Rezoning Transportation Analysis

Petition Number: 2024-022

Date	Description
3-27-24	First Review (IW)
04-24-24	Second Review (KC)

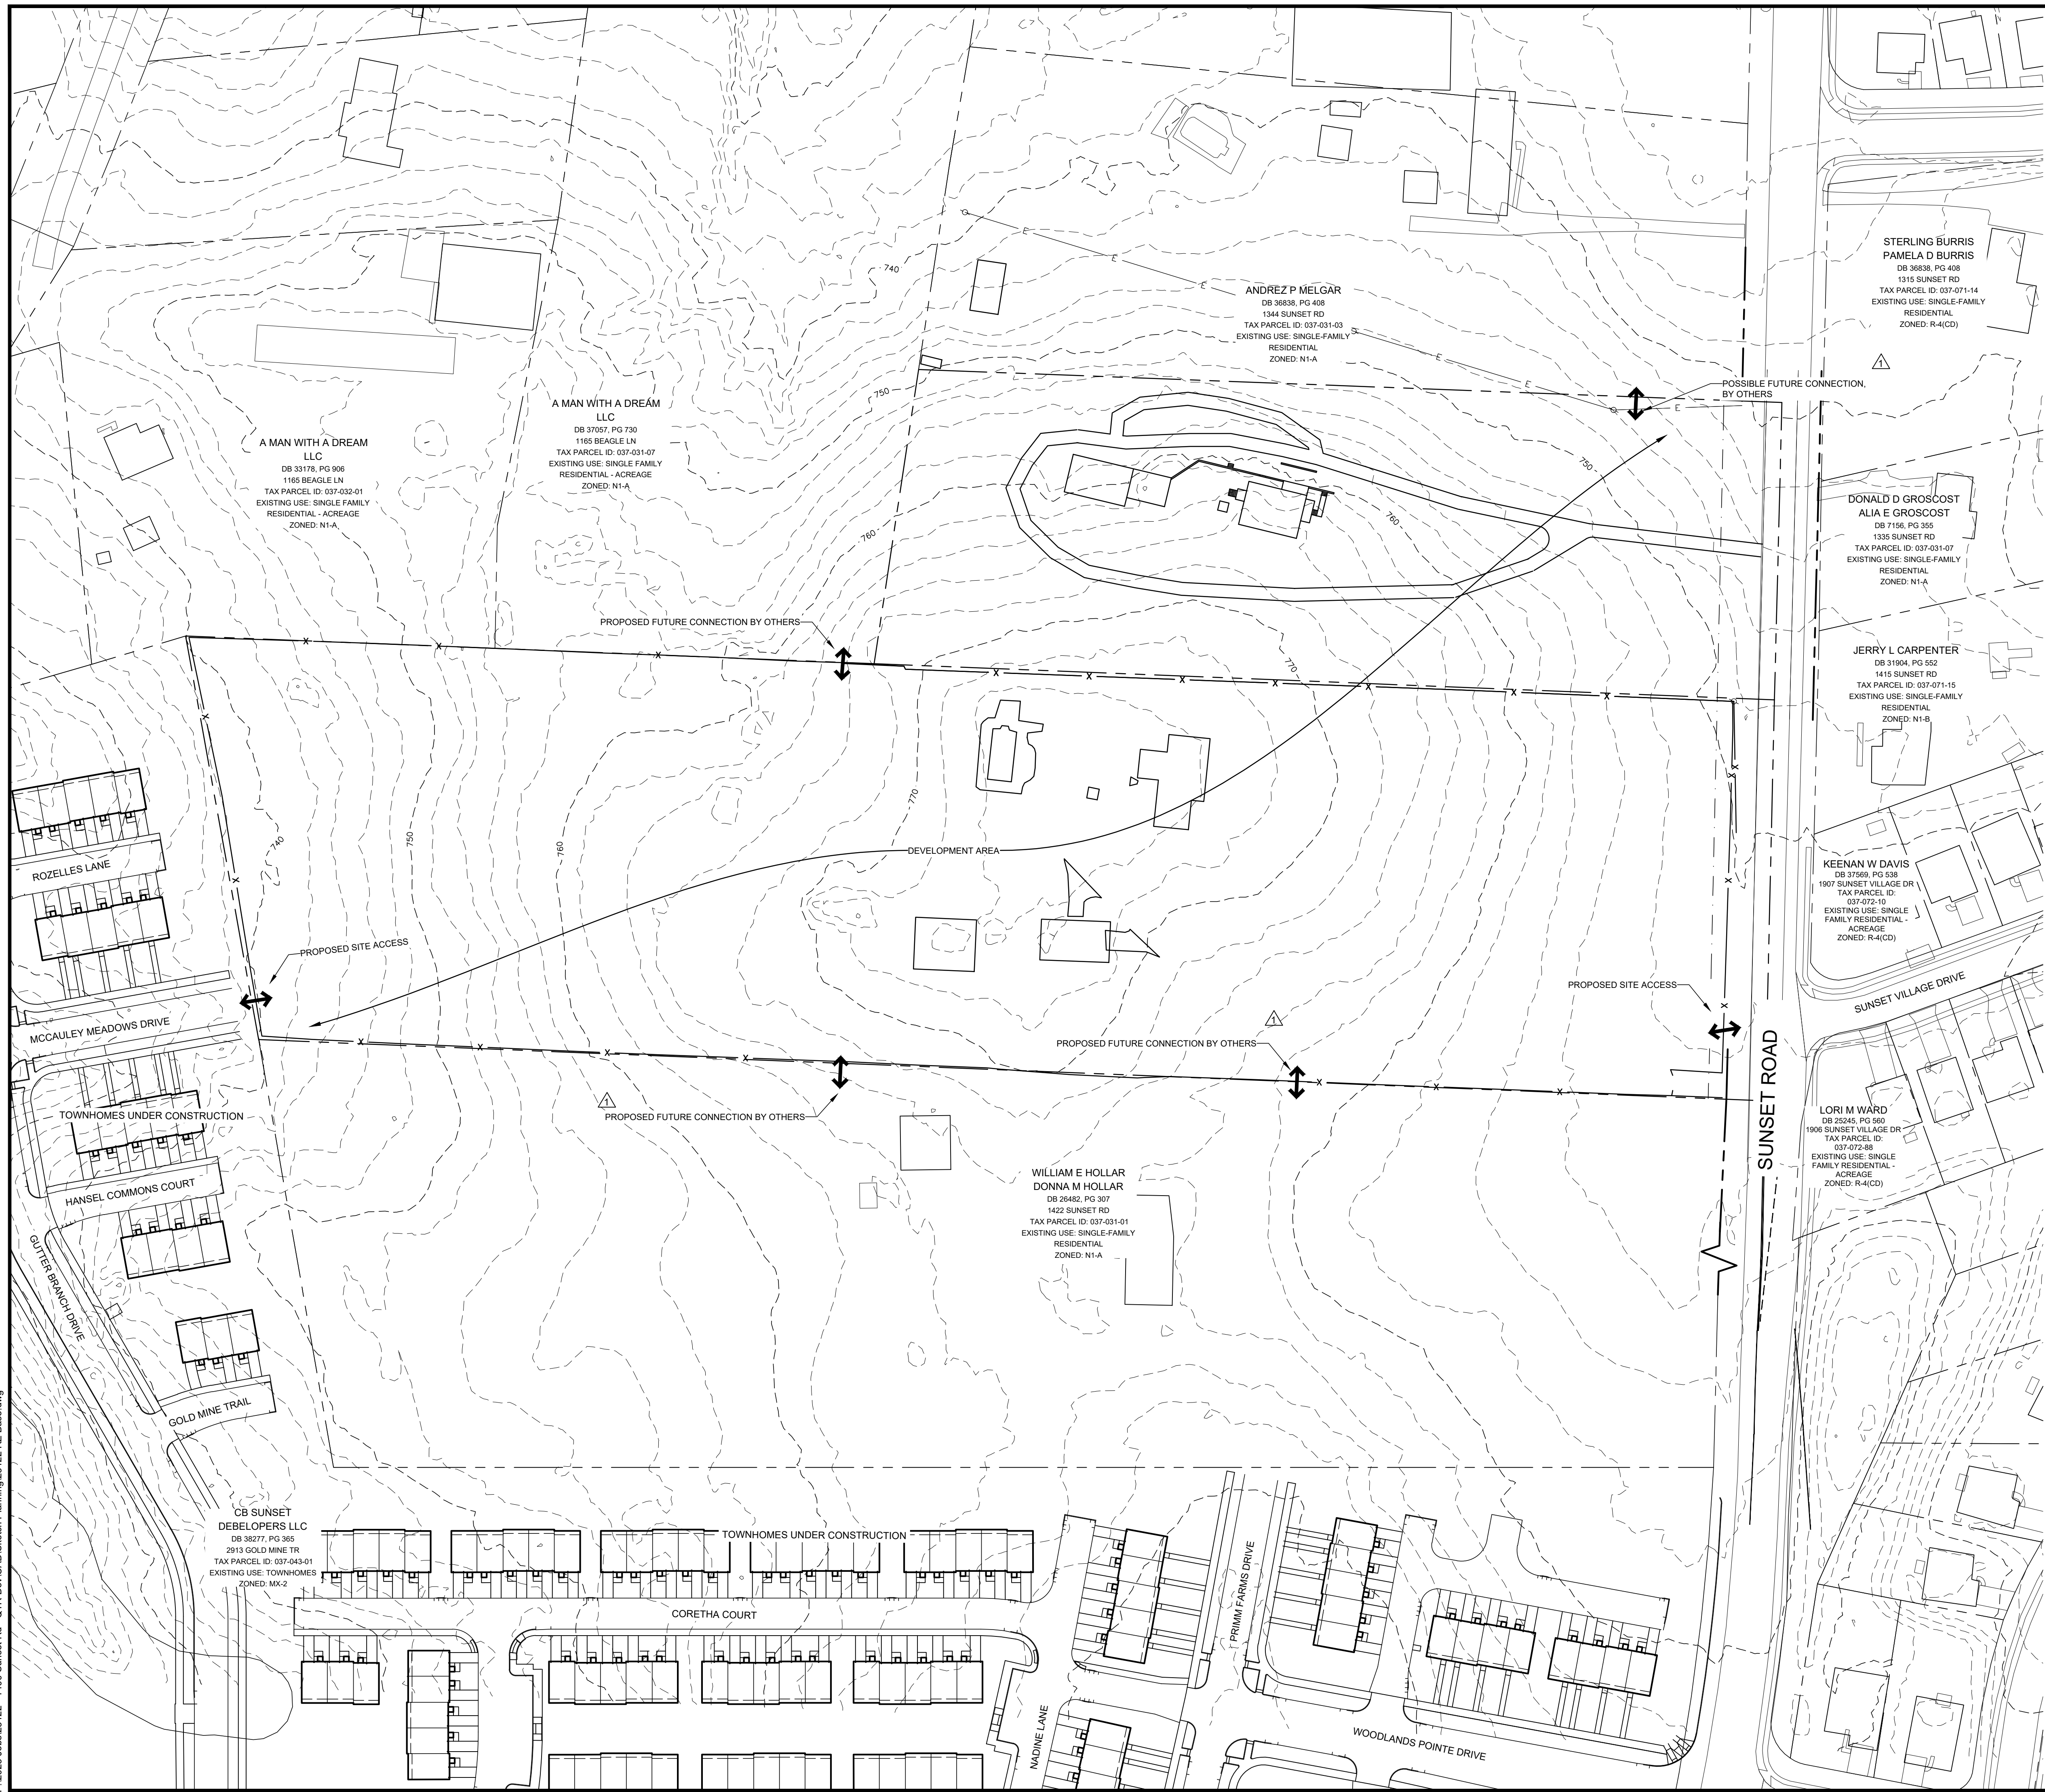
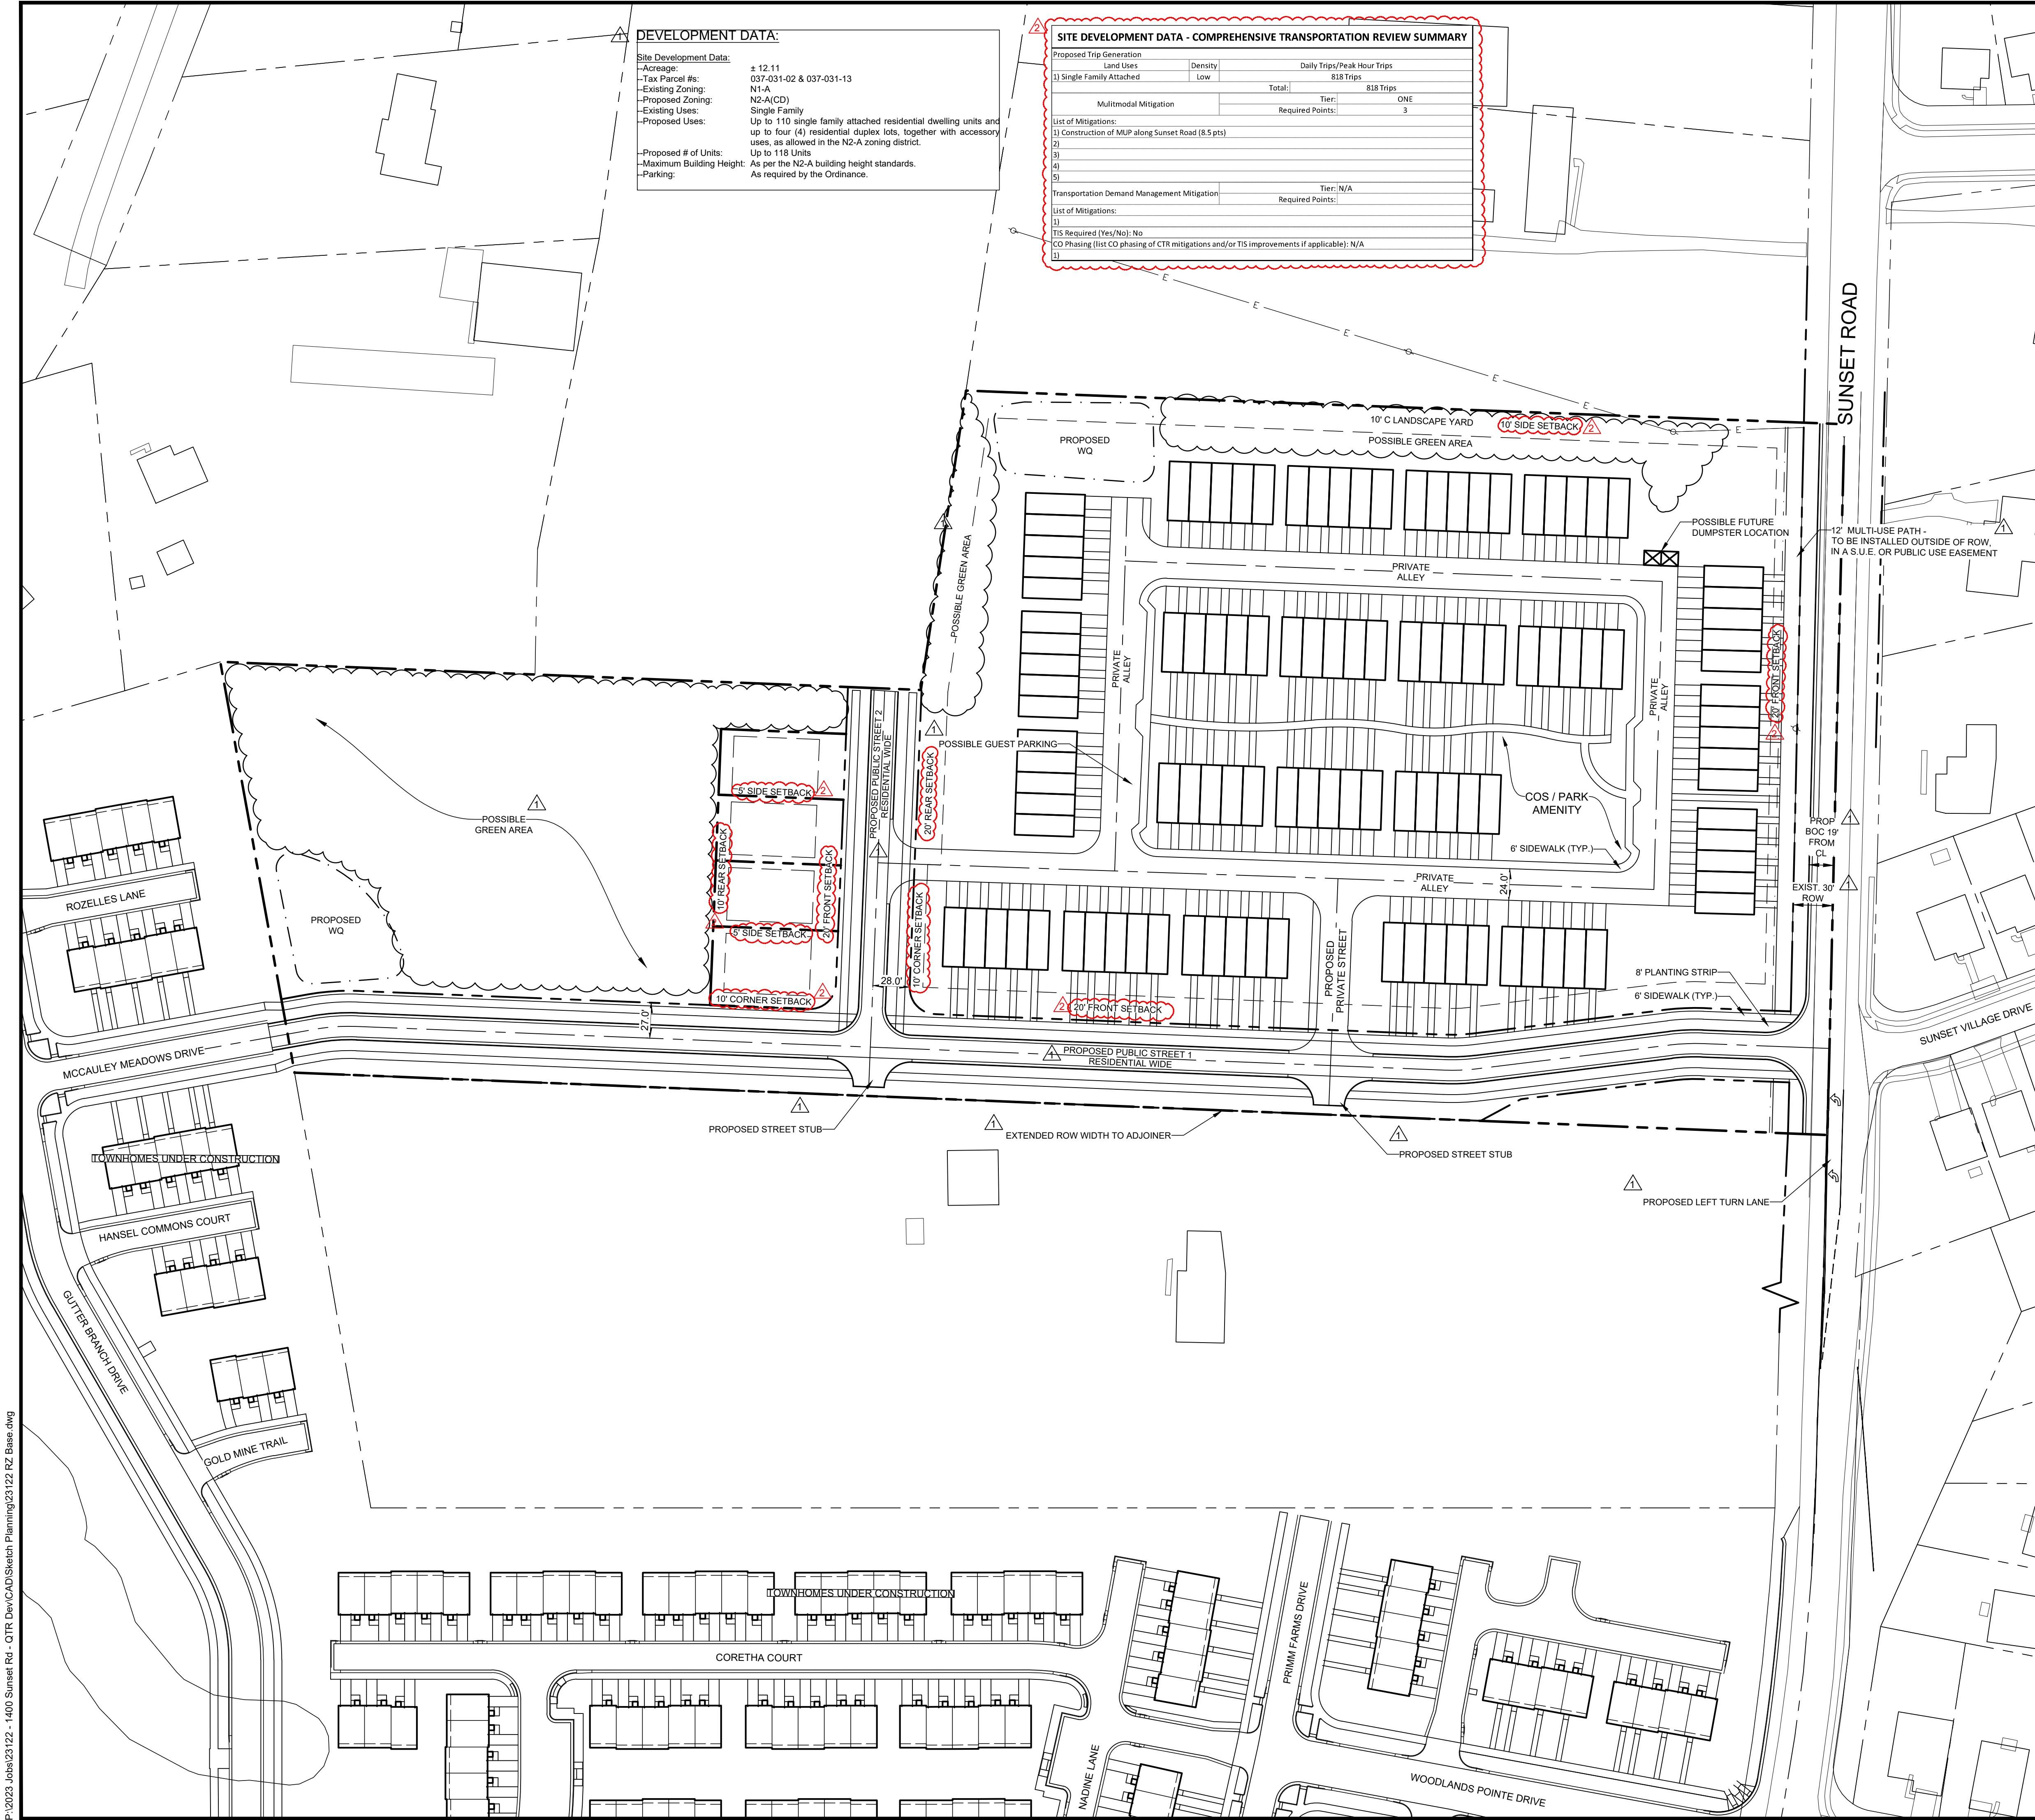
04-24-24 Outstanding Comment: Ramps internal to the site are not applicable for CTR requirements. Additionally, points for SUP are provided based on total length (.5 points per 25 linear feet constructed). Please provide total length of proposed SUP to verify the total number of points earned. Reach out to Ty Parham at ty.parham@charlottenc.gov for additional requirements.

6. Revise site plan and conditional note(s) to commit to creating cross-access with the Northern Parcel fronting Sunset Road per Article 31.2 in the UDO.
03-27-24 Outstanding Comment: Show proposed cross access with the Northern Parcel.
